The A38 Derby Junctions Case Team,
National Infrastructure,
The Planning Inspectorate,
Eagle Wing 3/18,
Temple Quay House,
Temple Quay,
Bristol,
BS1 6PN,

25th October 2021

Re: A38 Derby Junctions TR010022 8.121 Applicant's Response to Secretary of State's Statement of Matters of 2 August 2021

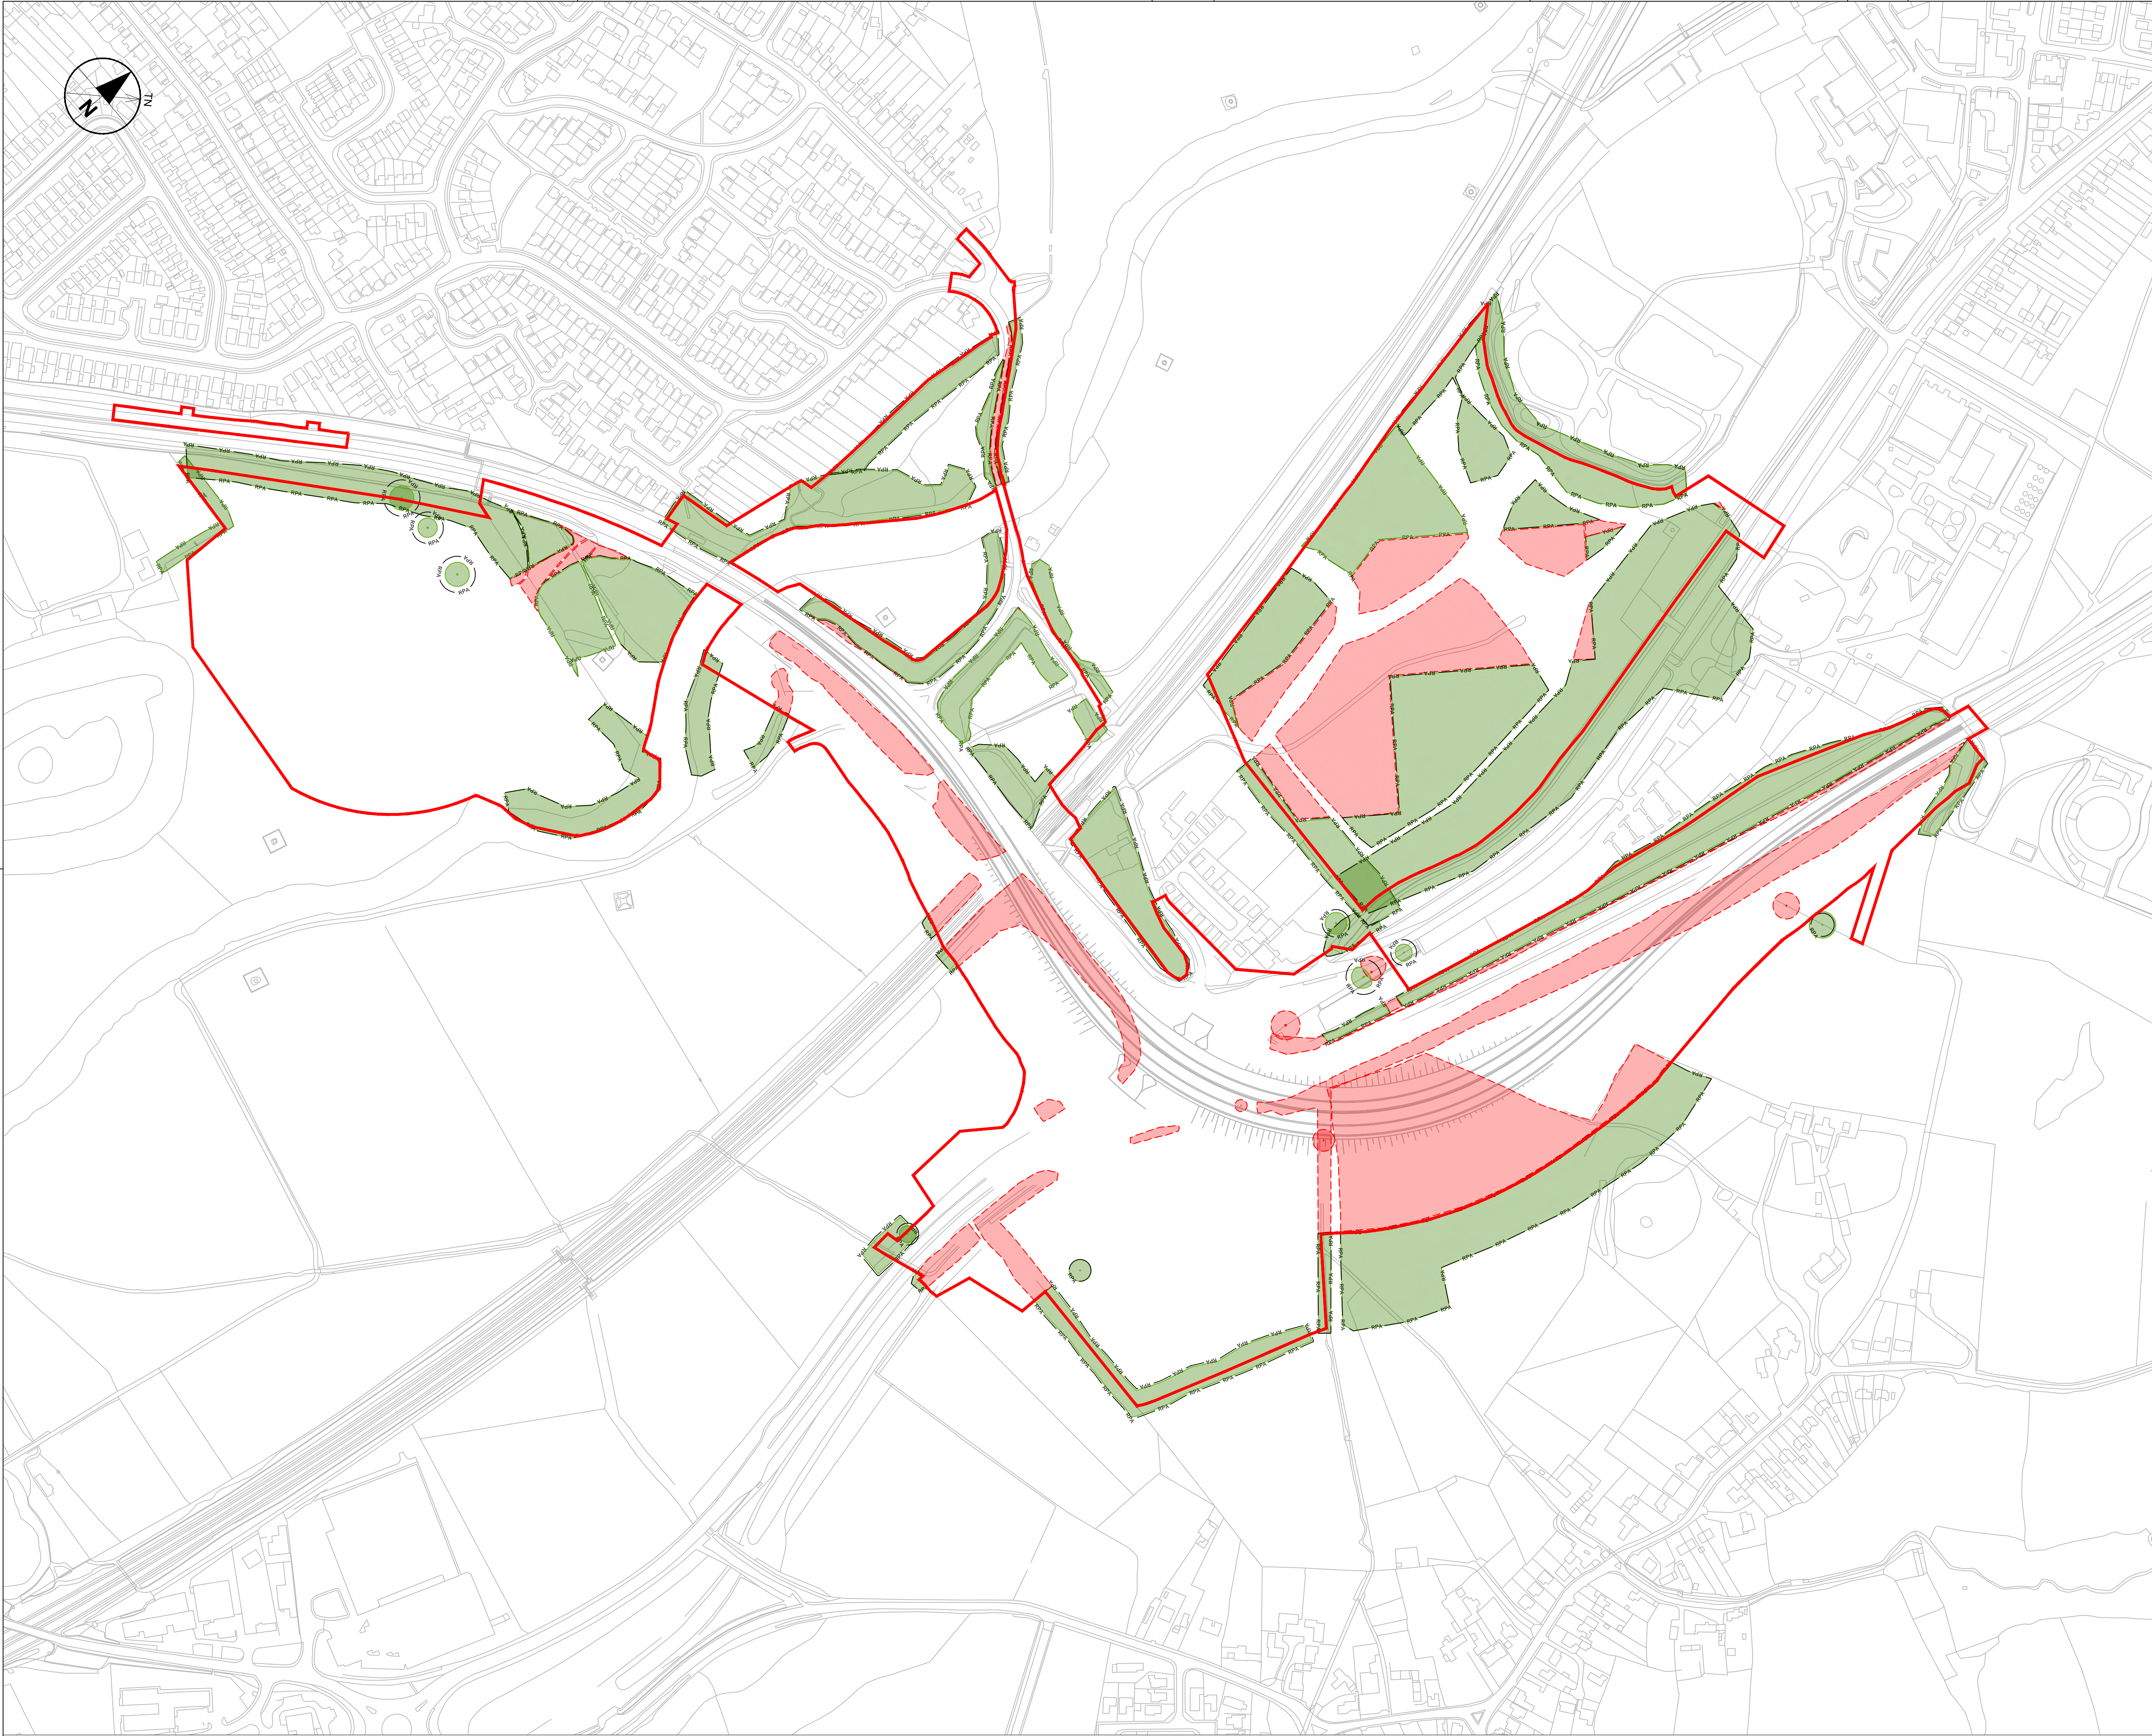
With regard to section 8 and the potential impact on the veteran oak tree there remains uncertainty on Highways England's part as to whether or not this tree will be retained. We consider that the tree should be retained in situ. Veteran trees are irreplaceable habitats and impacts should in the first instance be avoided.
